Our Ref: AL/8/18/PL

**Town & Country Planning Act 1990 (as amended)
Town and Country Planning (Development Management Procedure) (England) Order 2015
Application for Planning Permission**

Development Erection of 2 No. 2 bedroom dwellings with associated parking & landscaping.
Location Land between 8 & 10 Barnett Close Eastergate

Cycle shed plan and elevations

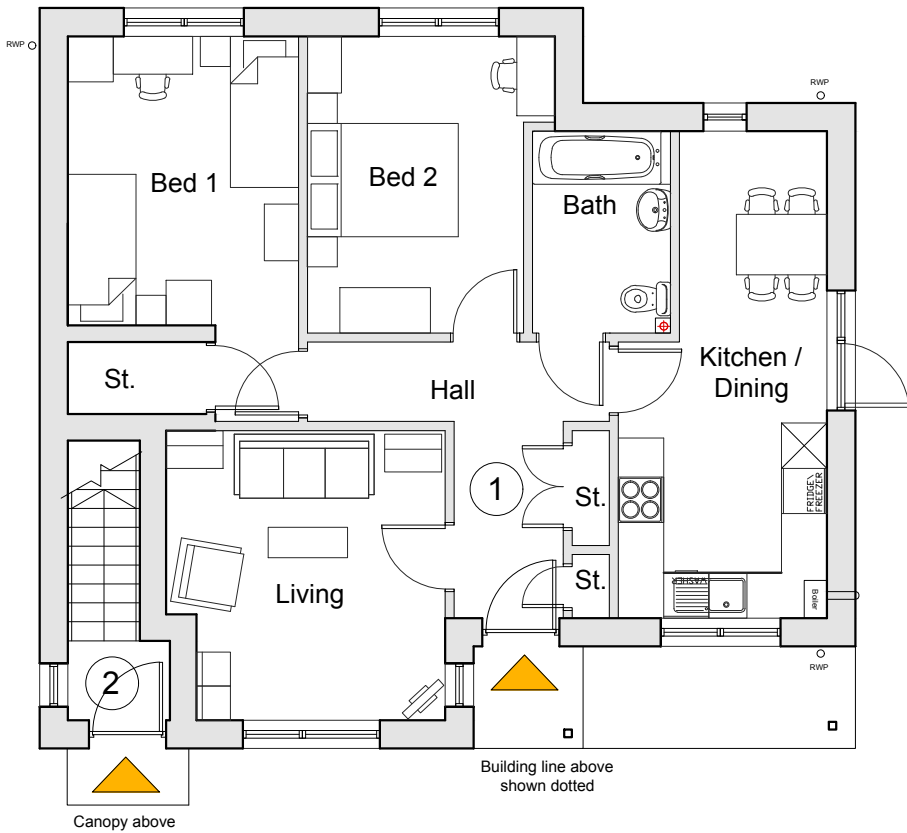
Please provide floor plans and elevations for the proposed cycle sheds.

location plan &
proposed site plan

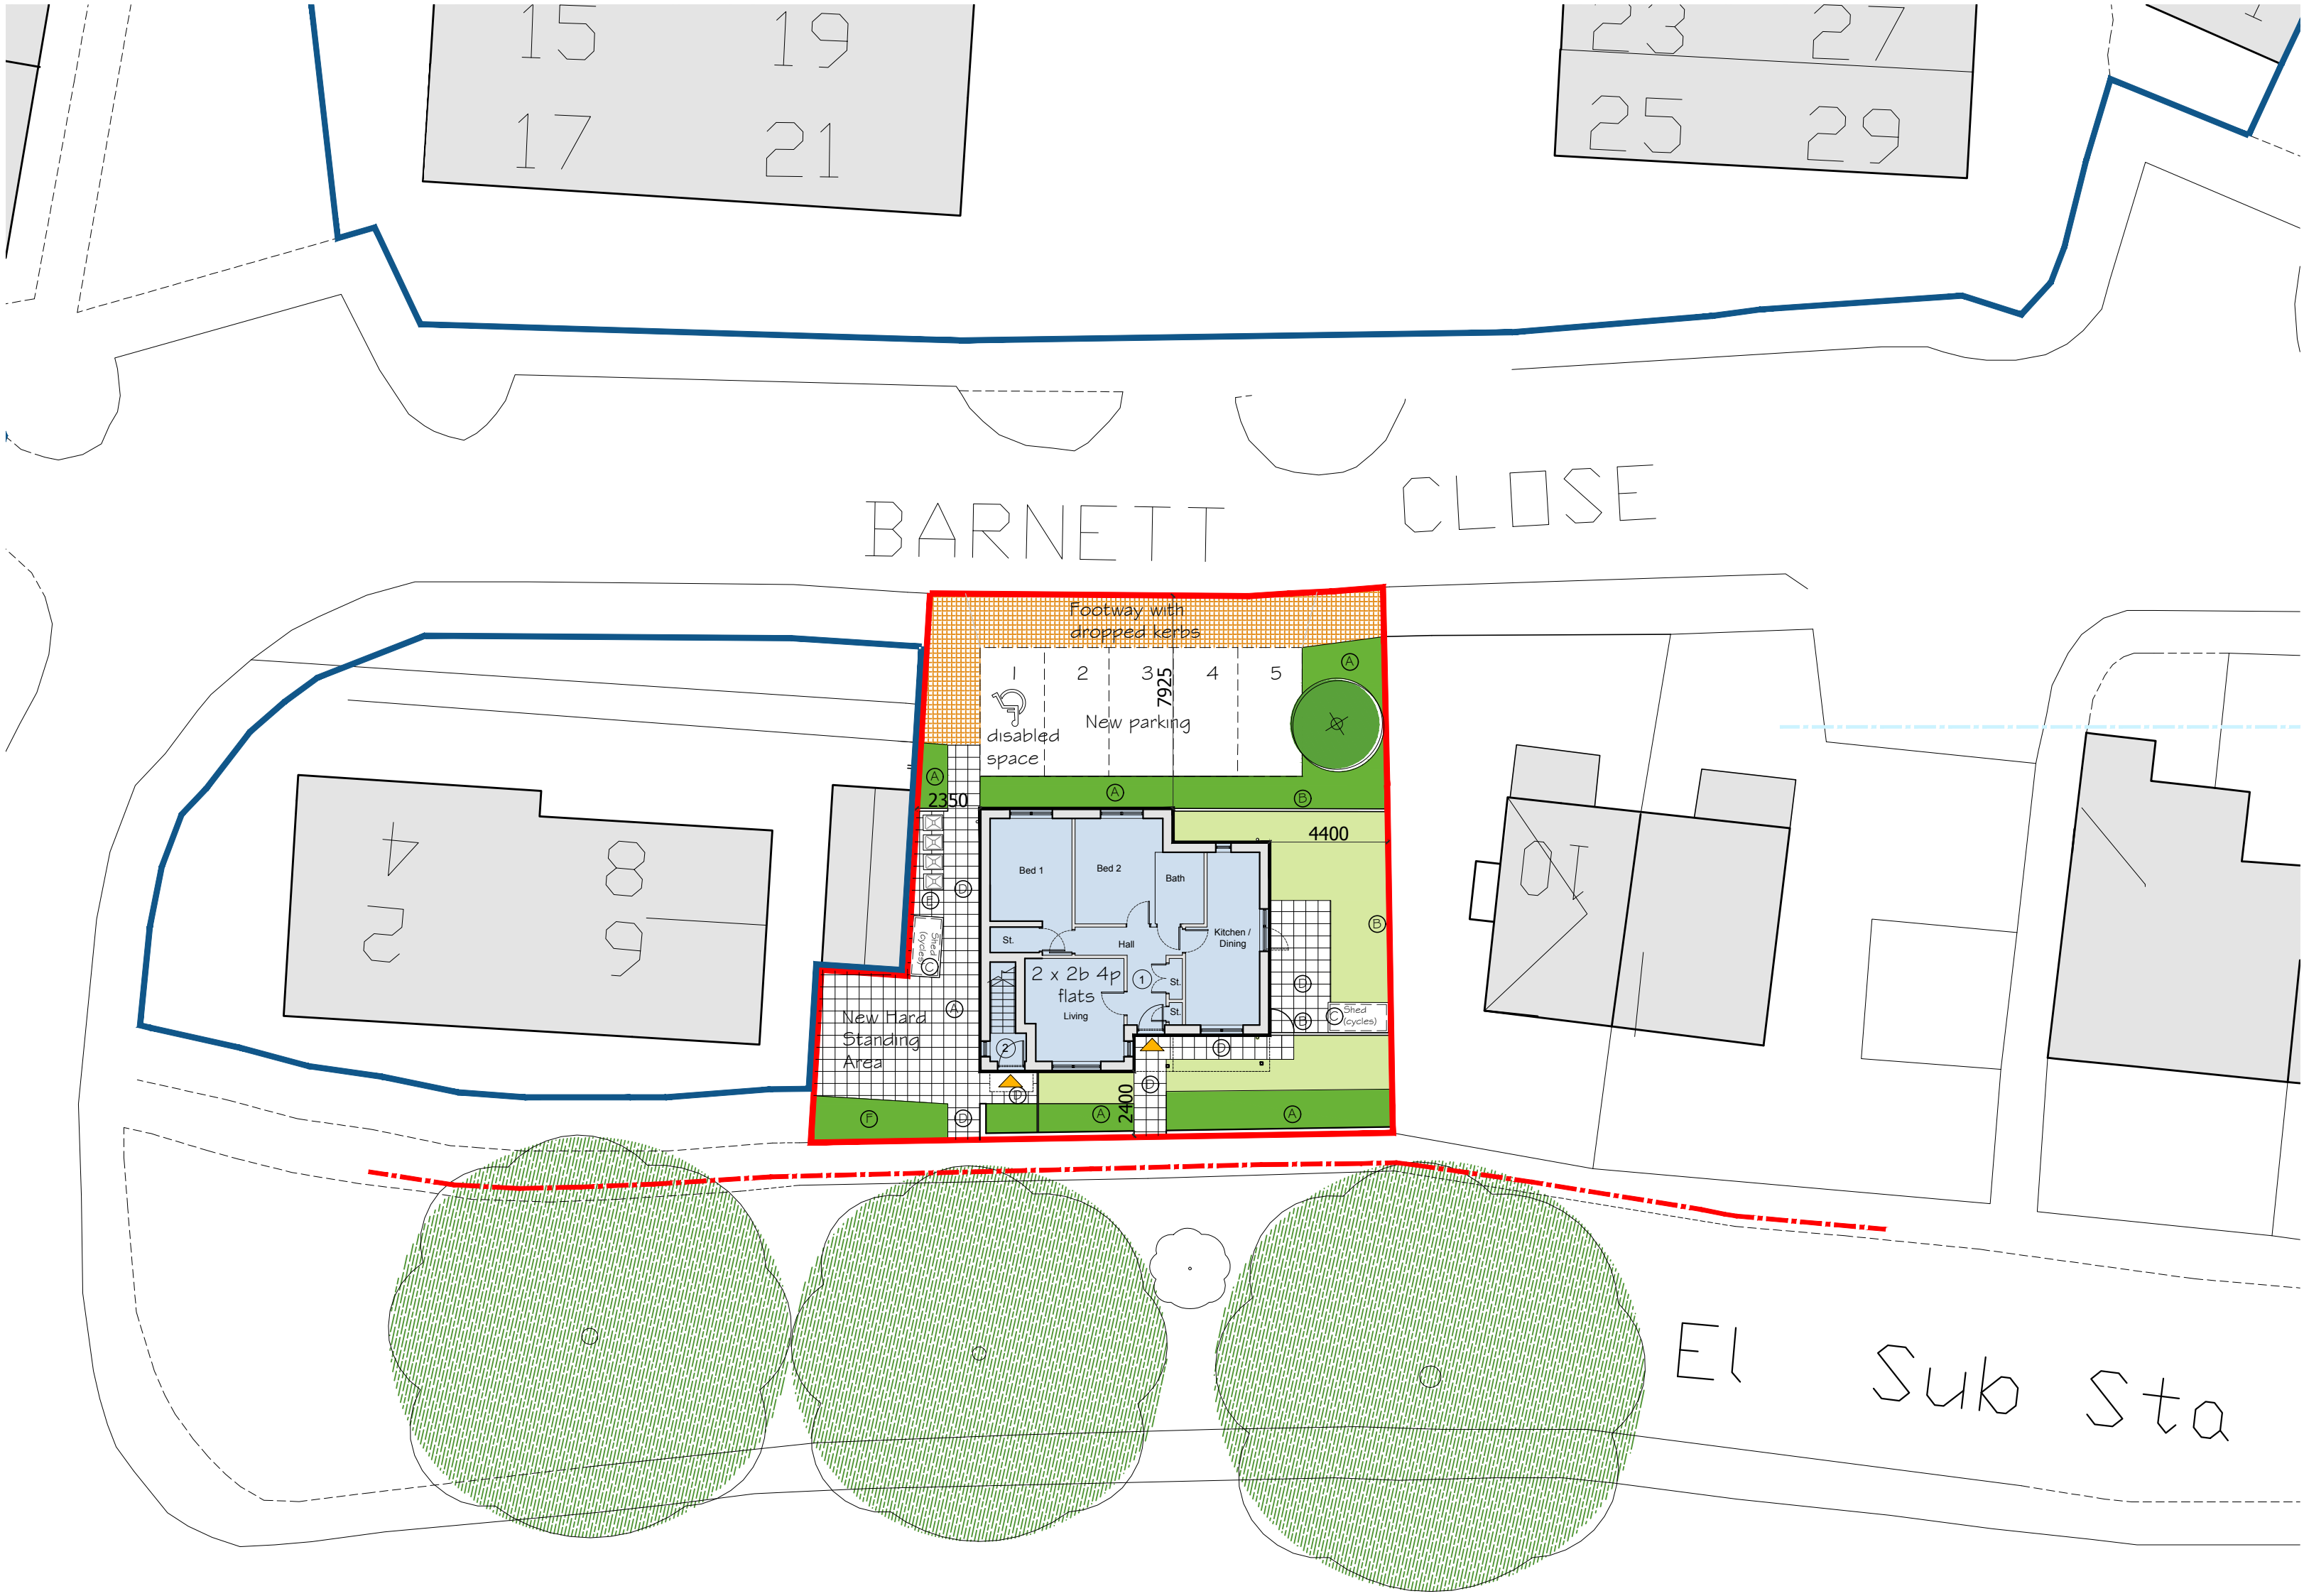
Block Plan Amend

Please submit 1 electronic or 3 paper copies of a block/site plan at a scale of 1:500 or 1:200. Further details of what must be included on the plan can be found in the National Validation Requirements. Please provide measurements from the proposal to the site boundaries.
